Your ref 3/2025/0652
Our ref DC/25/2452v3
Date 12-DEC-25

Location: Hall Barns Farm Knowles Brow Hurst Green BB7 9PT
Proposal: Proposed extension to existing approved agricultural building.

Drawing Title
 PROPOSED SKETCH PLANS
 (GROUND FLOOR)

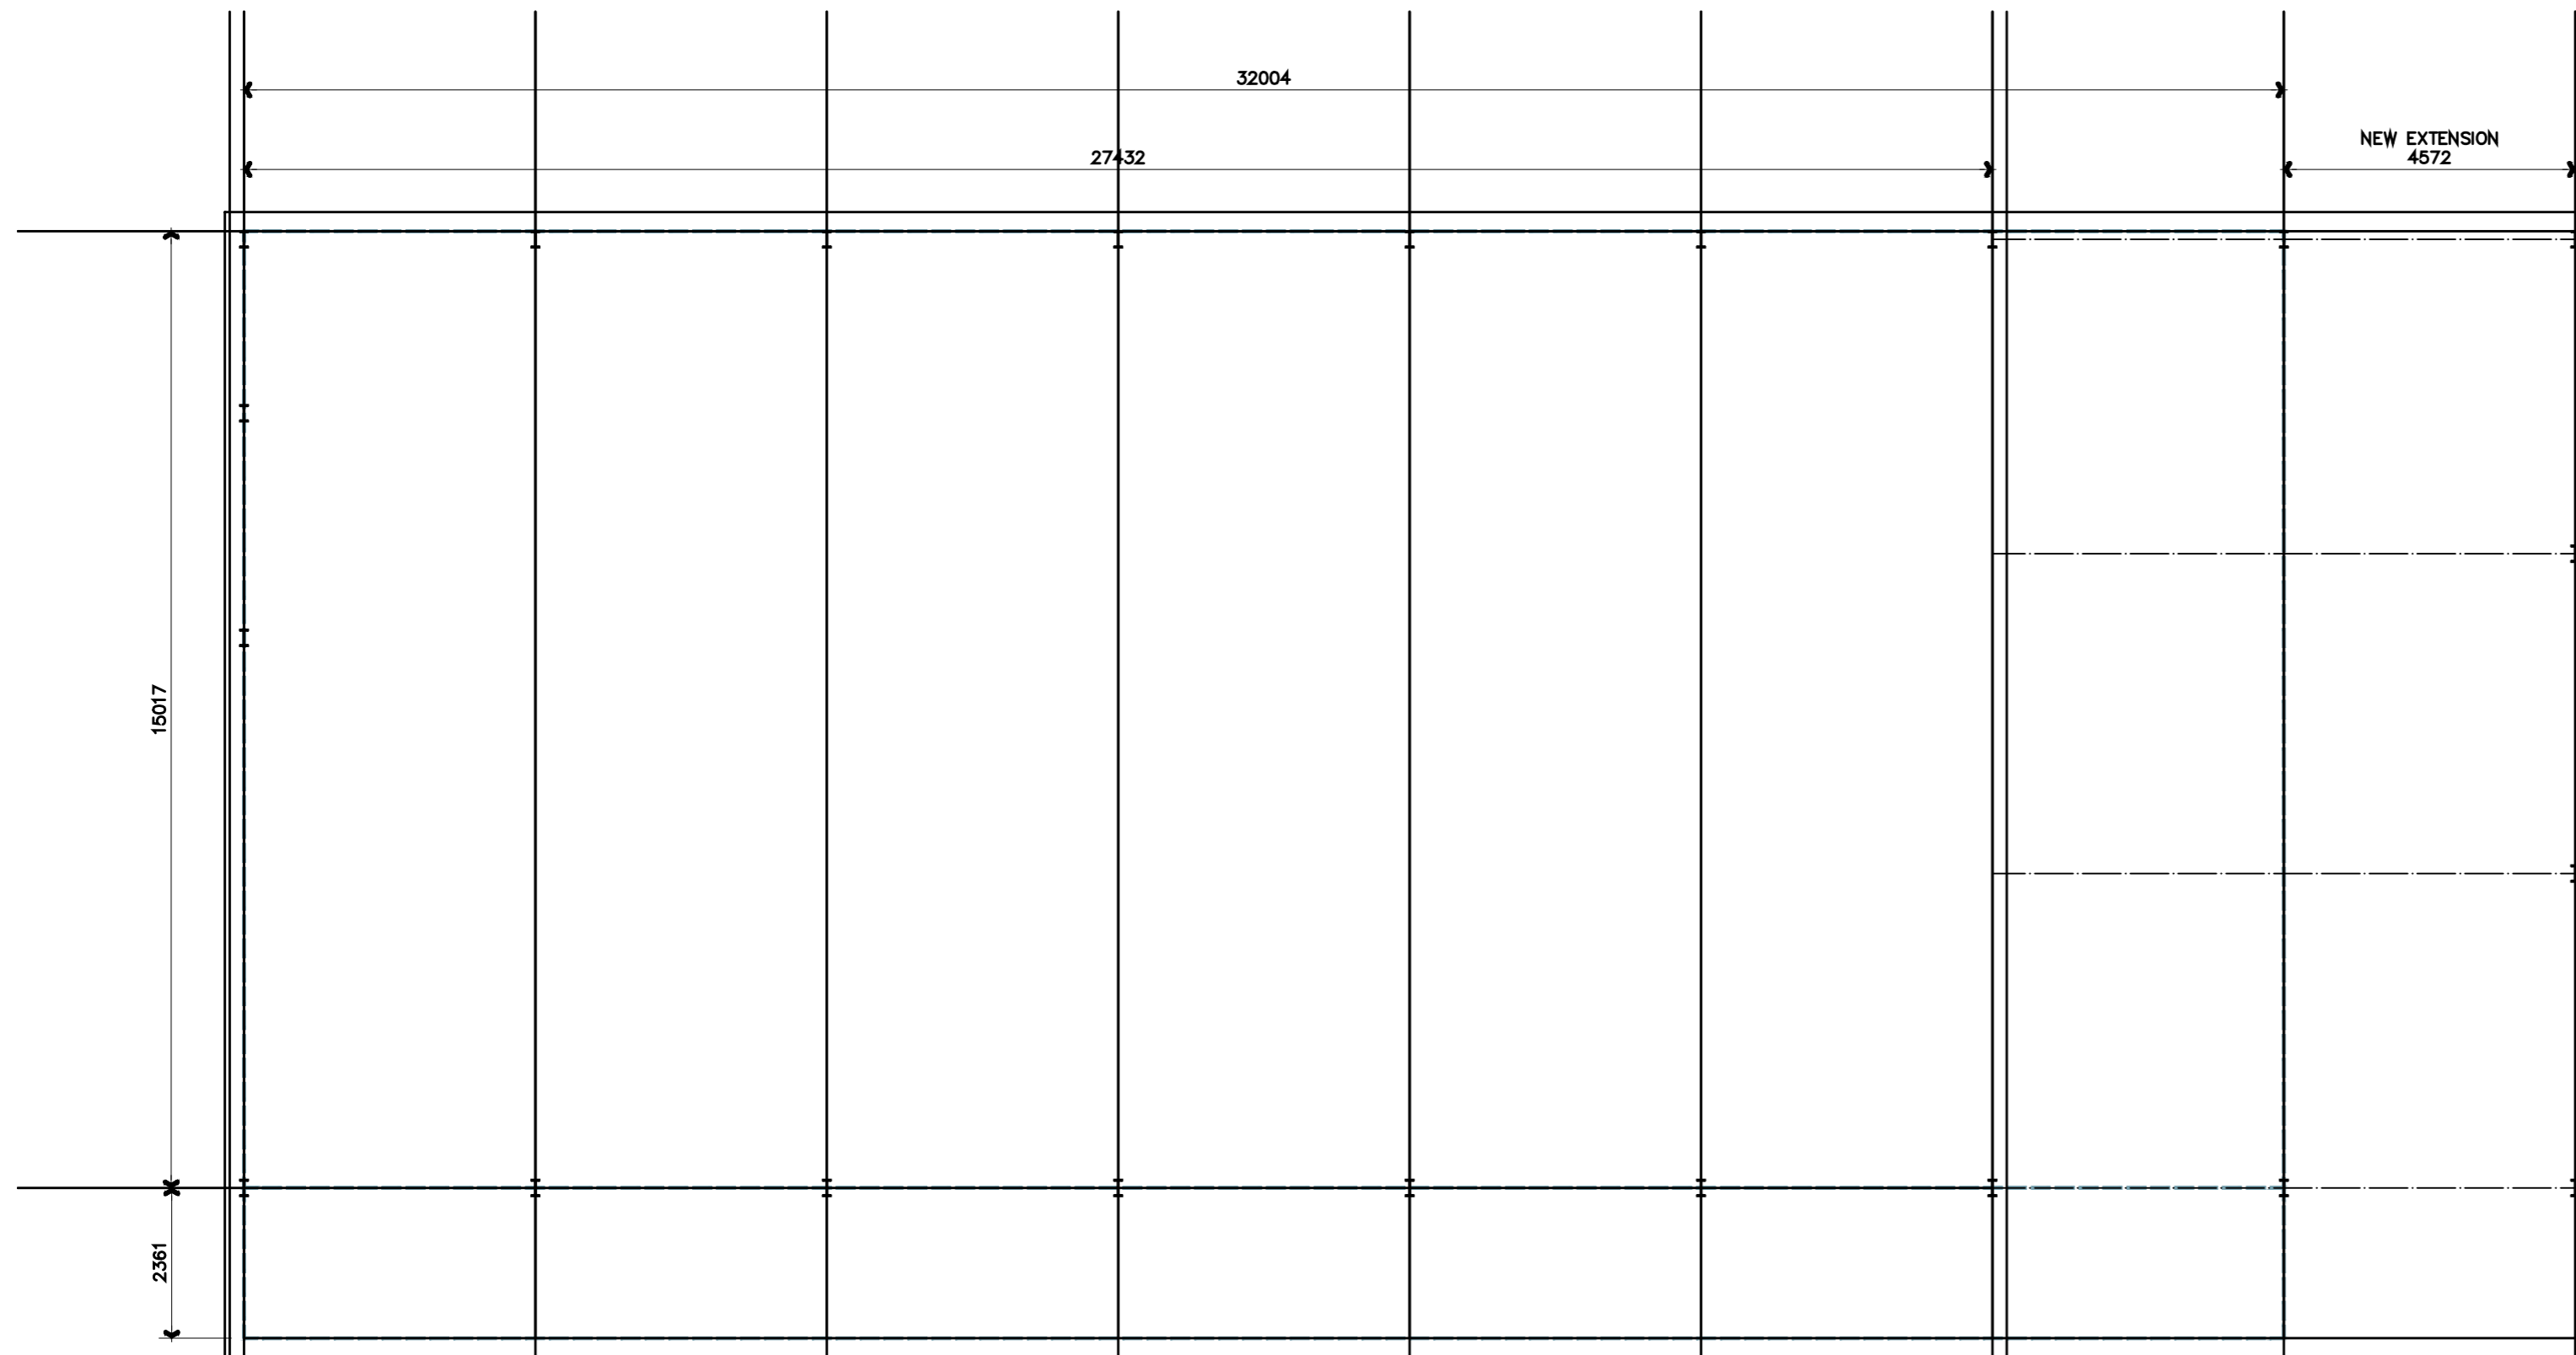
Following our review of the proposed site layout, whilst it appears that our required access to the water main is provided, based solely on the information contained within DRAWING No. 06B. The acceptability of any proposal is dependent upon the applicant knowing the exact location (line and depth) of the asset in question, confirmed through their site specific investigations. The precise location of United Utilities assets is critical as this could be material to the detail of the final site design; including any proposed crossings of the asset with either above or below ground features (including utility services).

We note the proposed plan sets out an easement width of 3m either side of the centreline of the pipe (location not confirmed). **The applicant should note that due to the size and nature of this asset, the easement width requirement is a minimum of 5m either side. We request the plan is amended and resubmitted as part of the planning application to demonstrate the proposed development is achievable with this wider constraint.**
